City of Albuquerque

June 28, 1984

REF DR. PETERSON'S OFFICE ADDITION (J14-D43) BLOK 17 ARMIJO
ADDITION.

Based on the information provided on your June 14, 1984 submittal of the above referenced site, listed below, you will find certain items that will need to be addressed before final approval is granted.

C-1

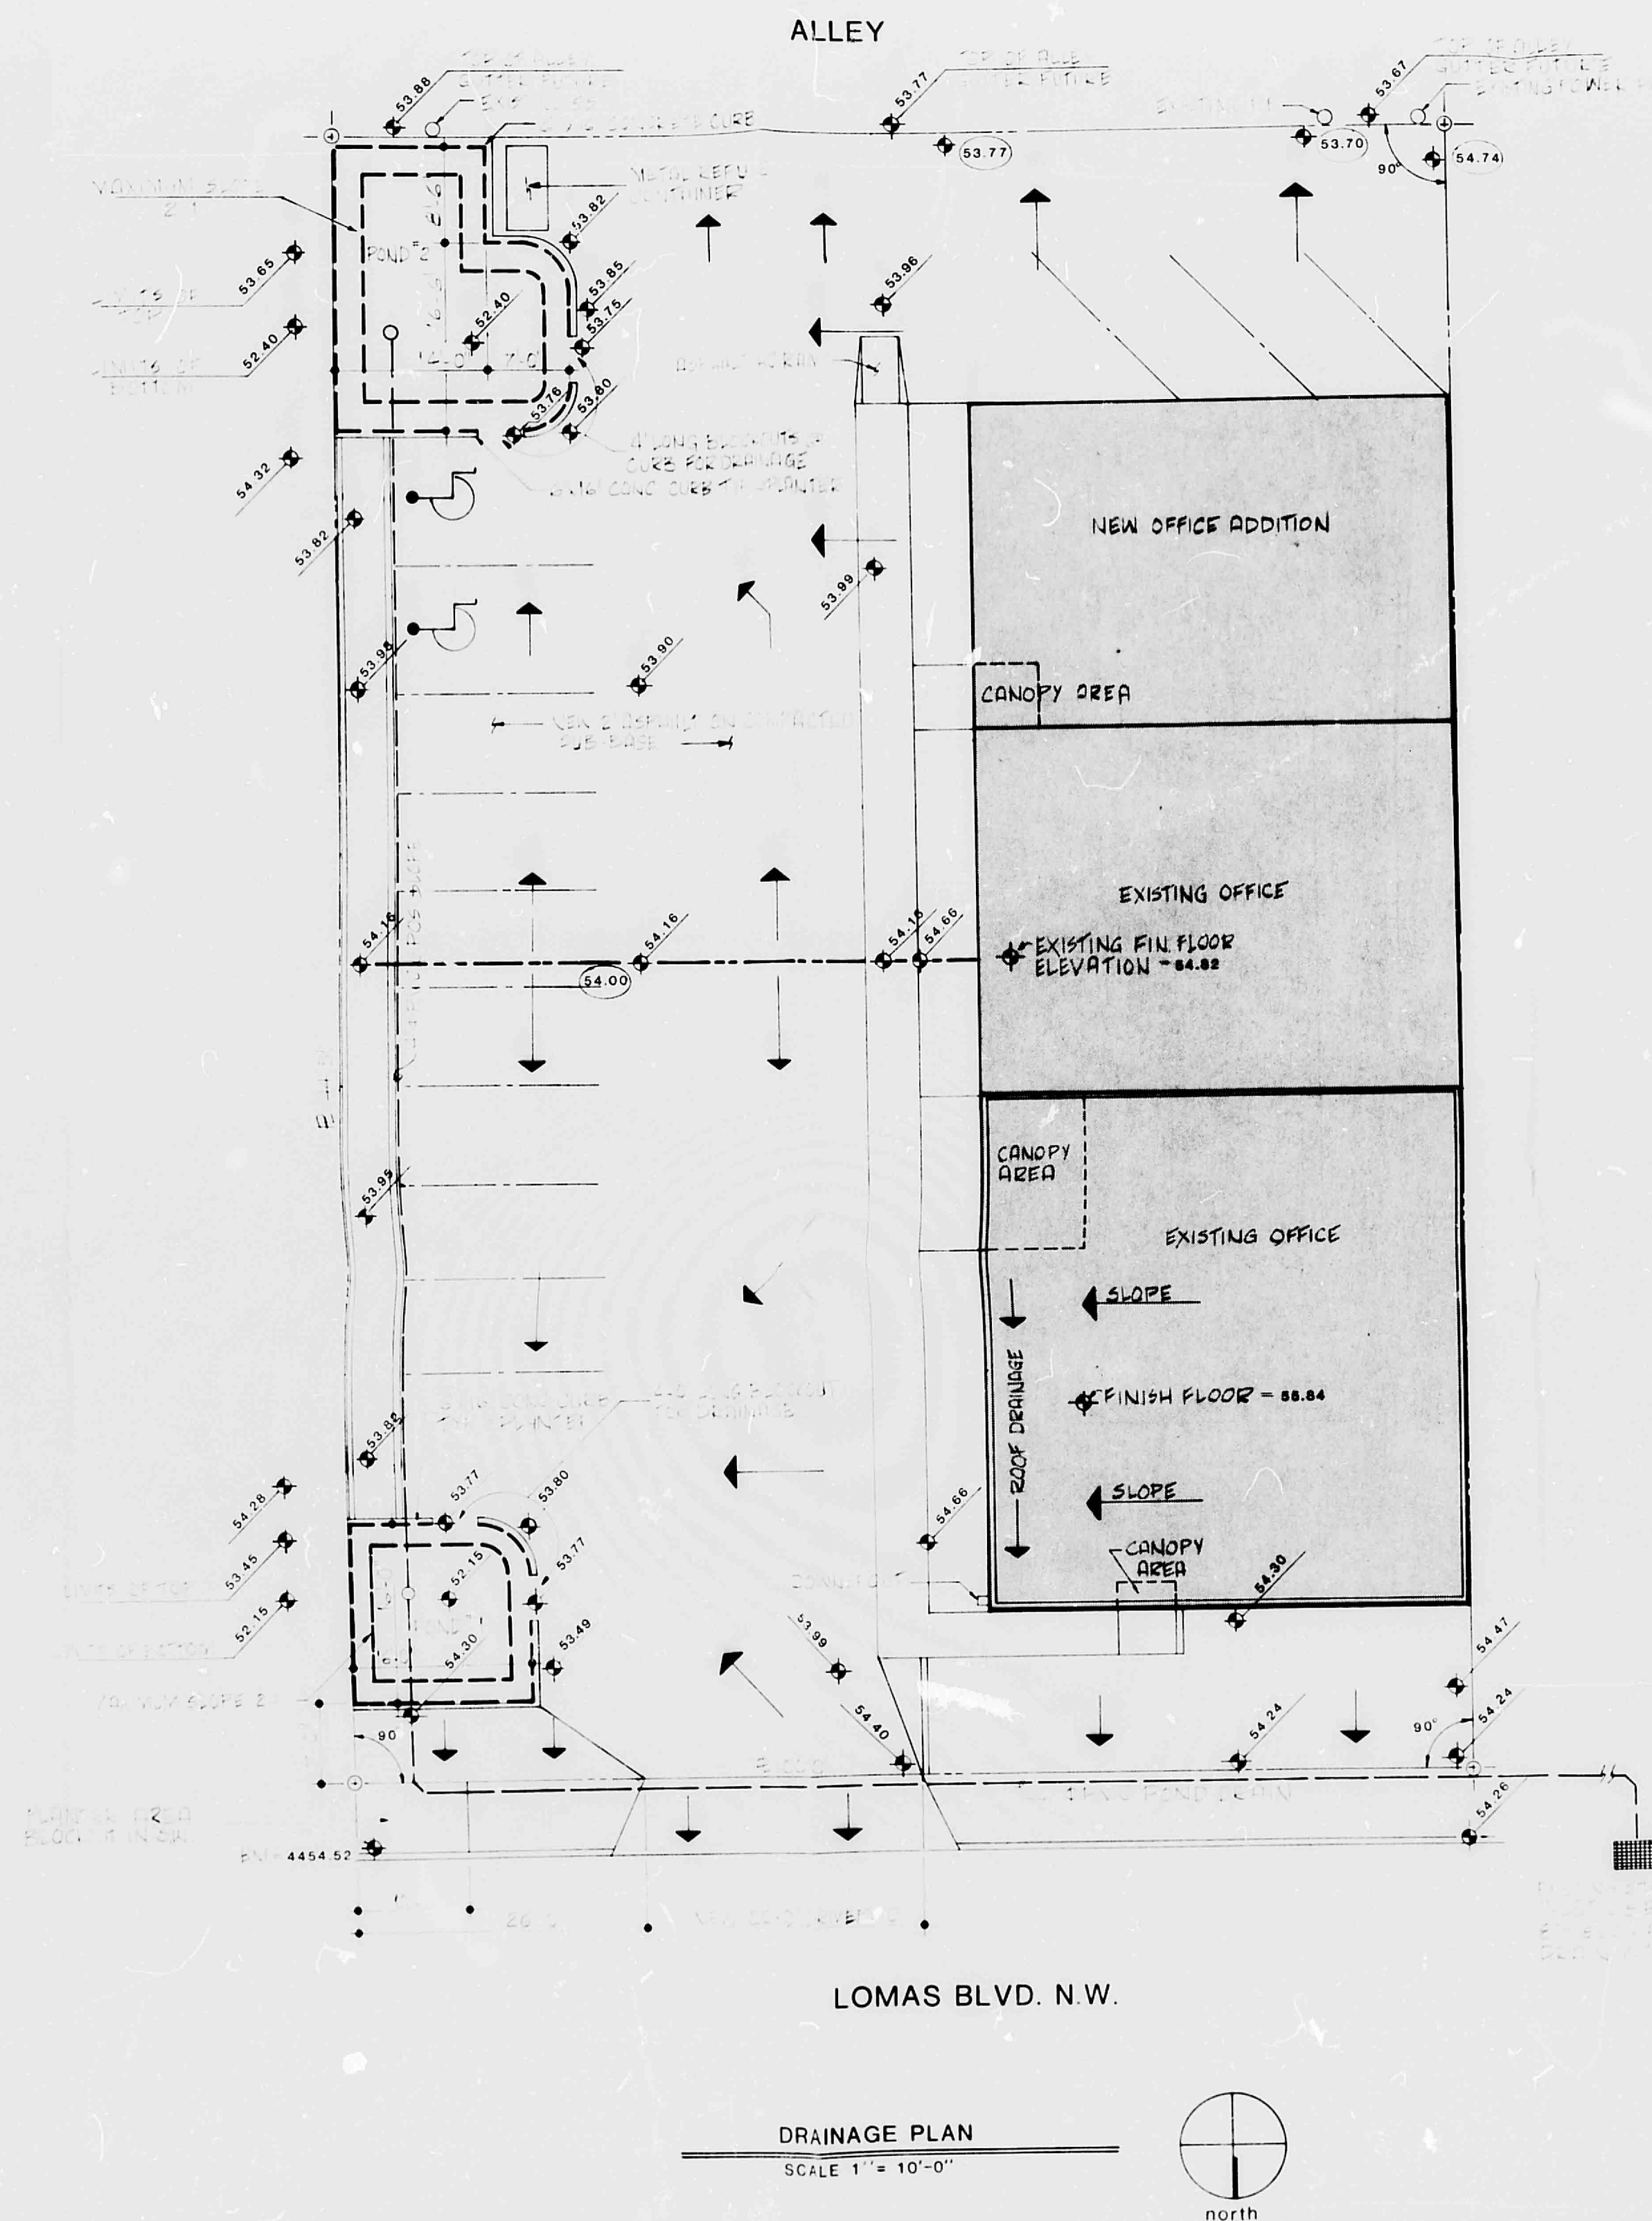
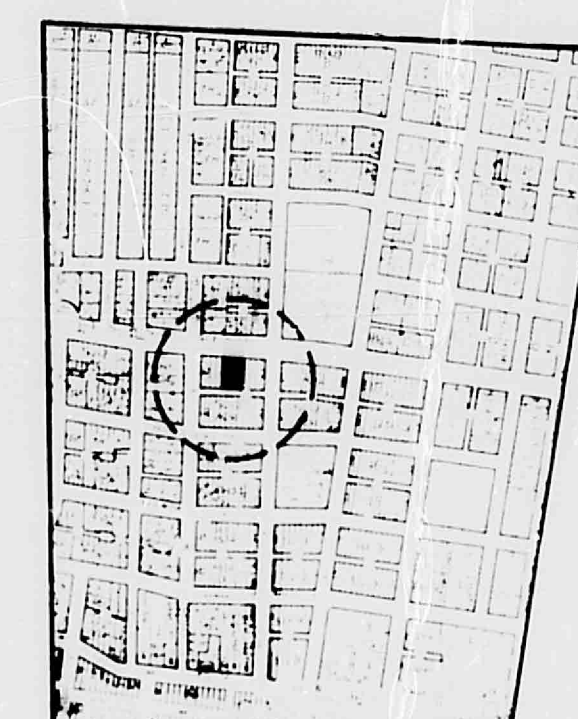
1. We will need an updated plan reflecting the proposed finish floor to mean sea level.
2. Also we will need the updated plan to reflect your professional stamp, signed and dated.
3. A notation will need to be inserted on the plan addressing the fact that the original ponding areas were eliminated and that they will be reconstructed per plan.
4. We will need verification from City Engineer's Office inspection section that they have inspected the tie in to the existing catch basin on Lomas.
